Engineers Comments Regarding Surface Water Drainage

Application Reference:	P/56/26/PL	Reviewer Reference:	ADC/EXT4b
Planning Officer:	Kathryn Welch	Date of Review:	02/07/2026
Site Name:	Land to the west of Inglenook Hotel 255 Pagham Road Pagham PO21 3QB		
Application Description:	Demolition of existing storage buildings and construction of 6 No. dwellings and associated works (resubmission following P/43/25/PL). This application is a Departure from the Development Plan and is in CIL Zone 5 and is CIL Liable as new dwellings.		
Assessment Number:	1

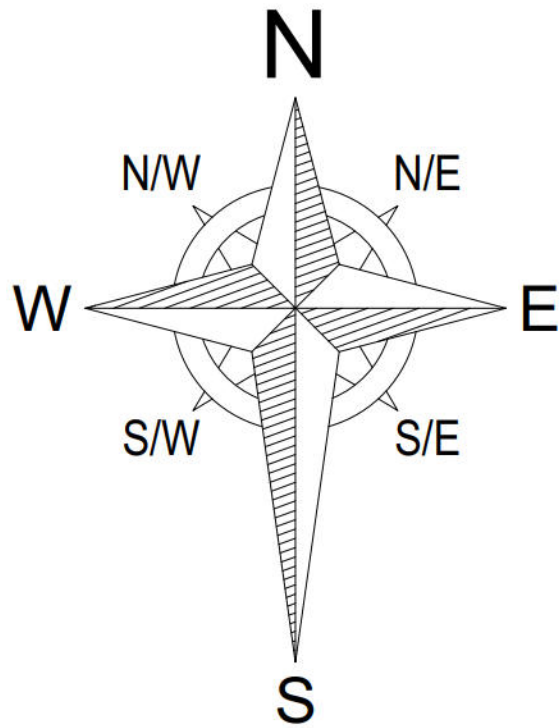
1.2. The designer has included green roofs on the garages, raingarden planters, water butts and permeable paving, all of which will provide interception drainage.

2.2. Climate change and urban creep are adequately allowed for in the calculations. There appears to be a discrepancy between the total catchment areas shown in the model simulation results and on the plans – this amounts to 30m². This may result in additional storage being necessary within the network, however, it is assumed that as all storage is subterranean this will be unlikely to affect scale and layout.

Inglenook
Appendix 7 - tree protection plan - phase 2

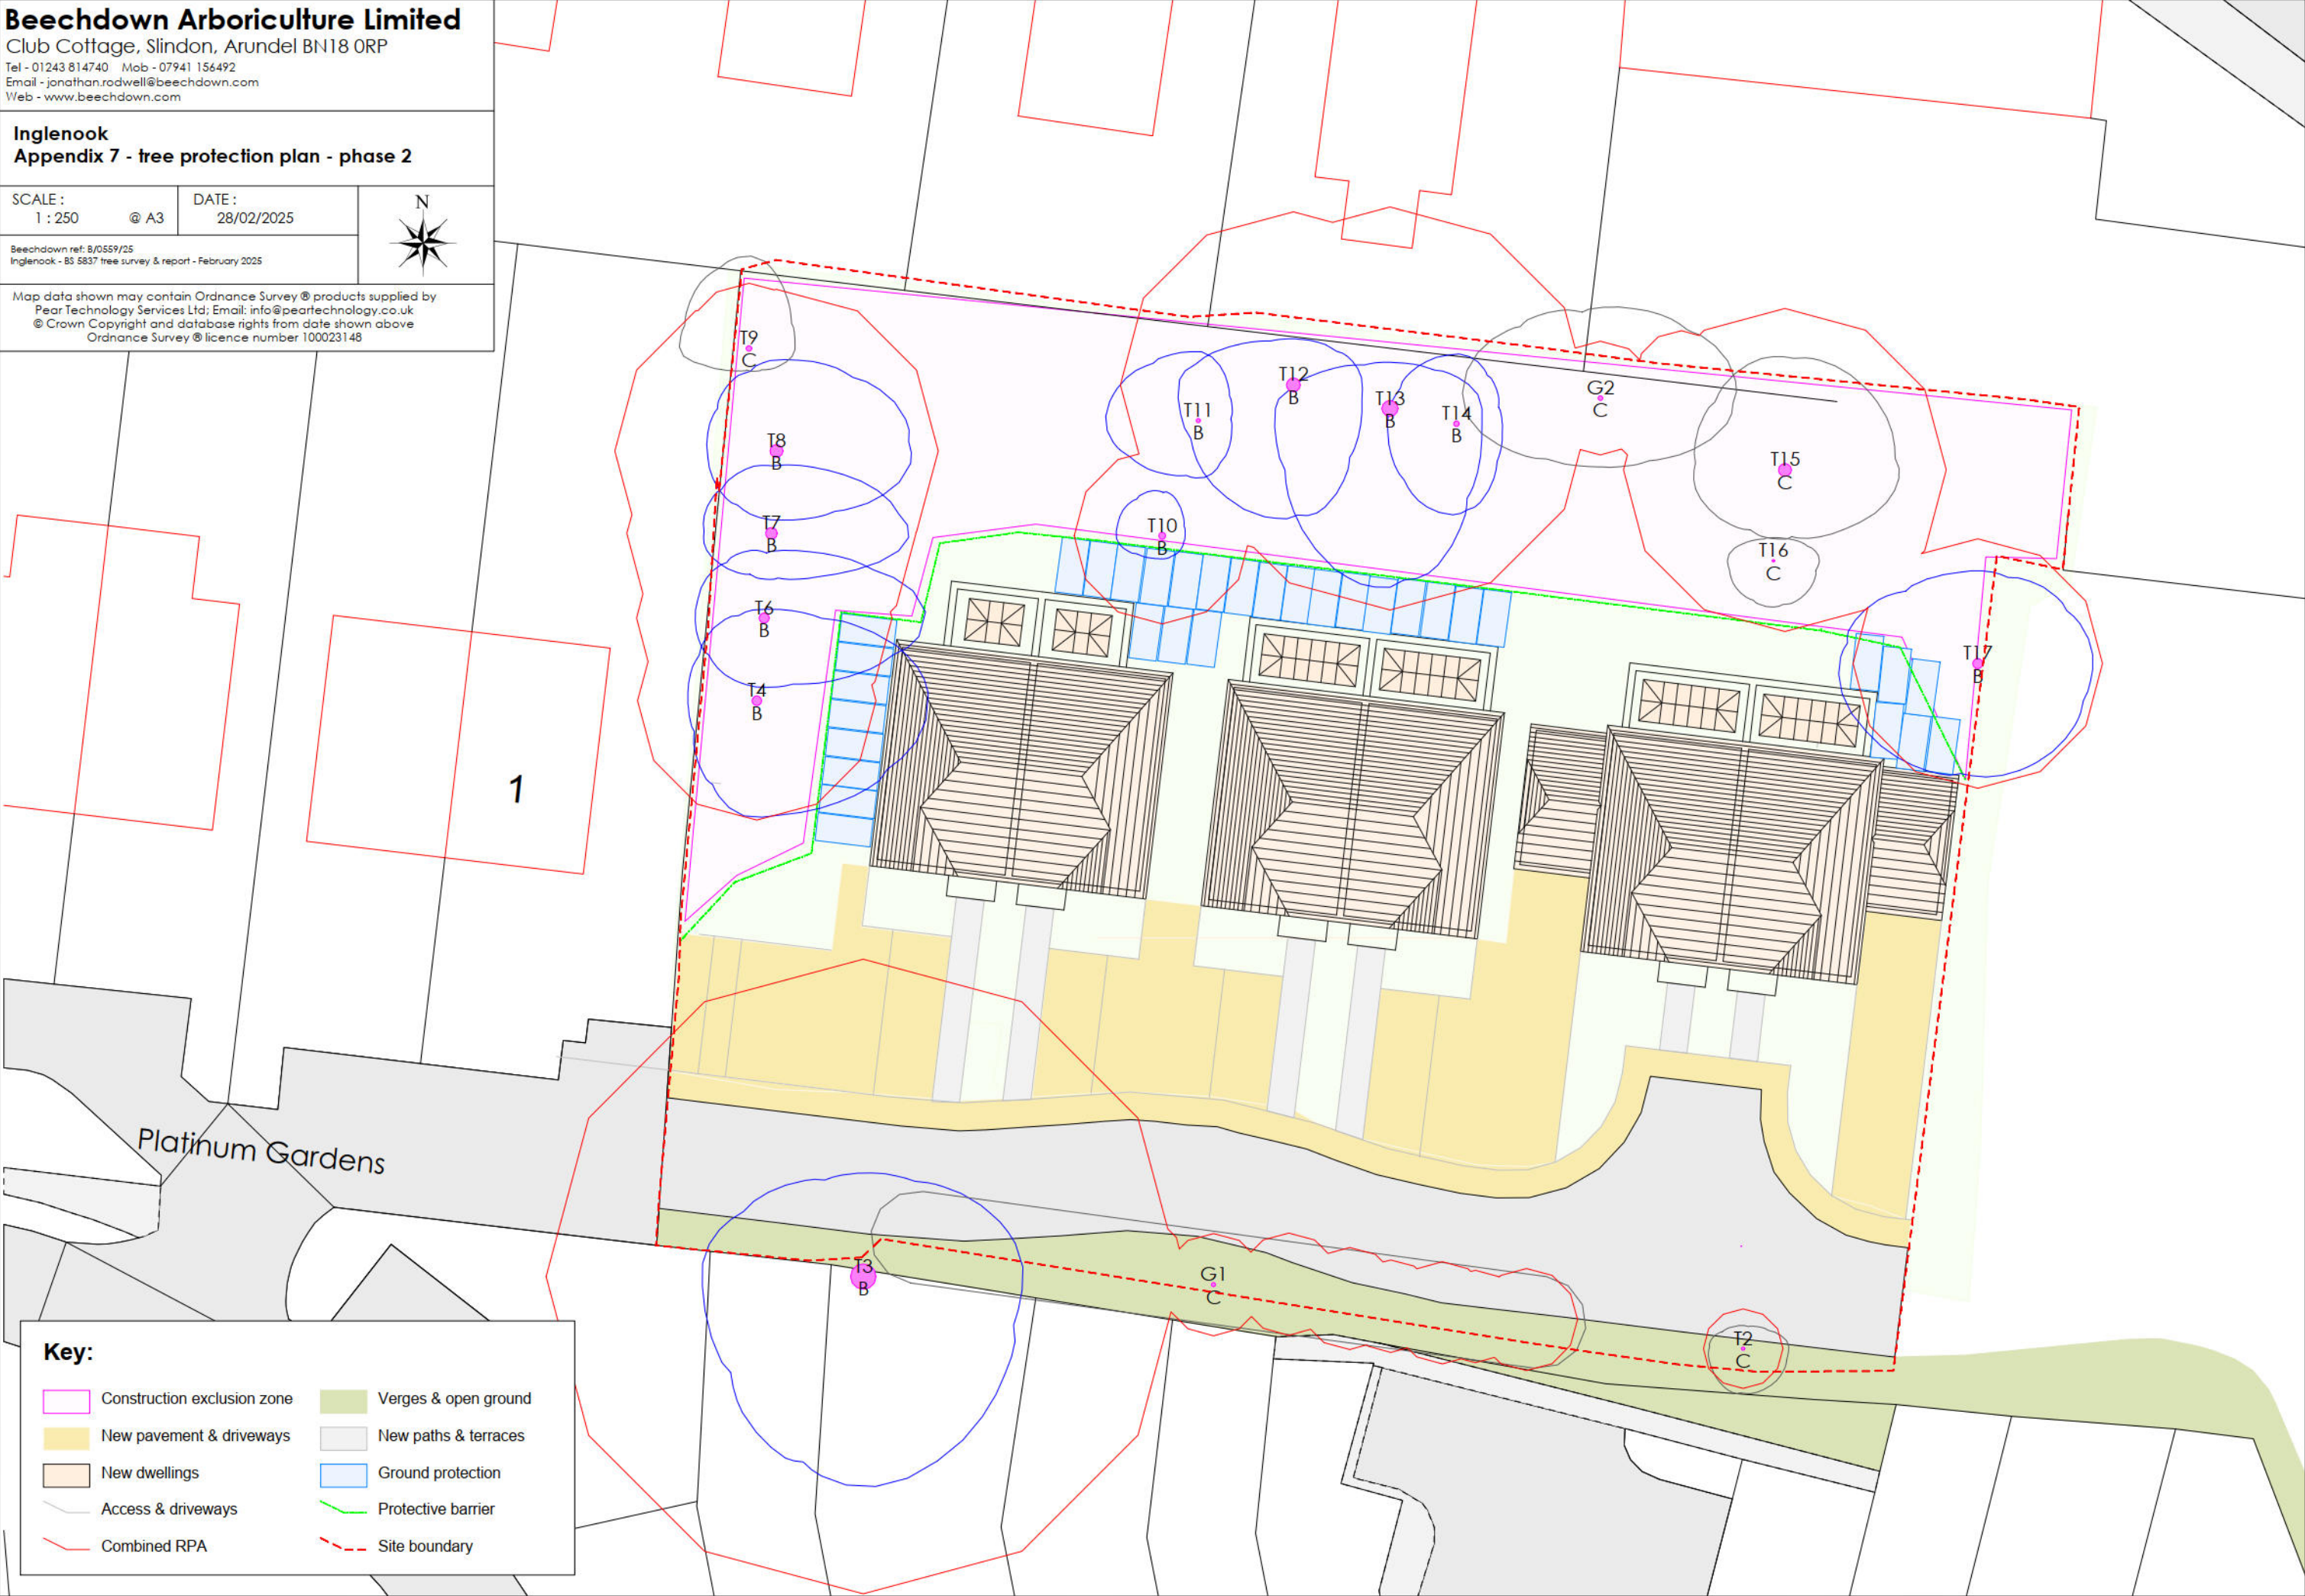
- 5.2. There is an existing TPO tree offsite, the root protection area for this encroaches into the site and affects the construction of the shared access road. The construction of the road is lined (tanked). It is advised that the tree officer is consulted to ensure that the drainage strategy does not impact the existing tree. Pre-application discussion was had with the tree officer who had previously requested that a submission was made by the applicant's arboriculturist in this regard – however it is unclear if this has been submitted. The current proposal is satisfactory from a drainage perspective.
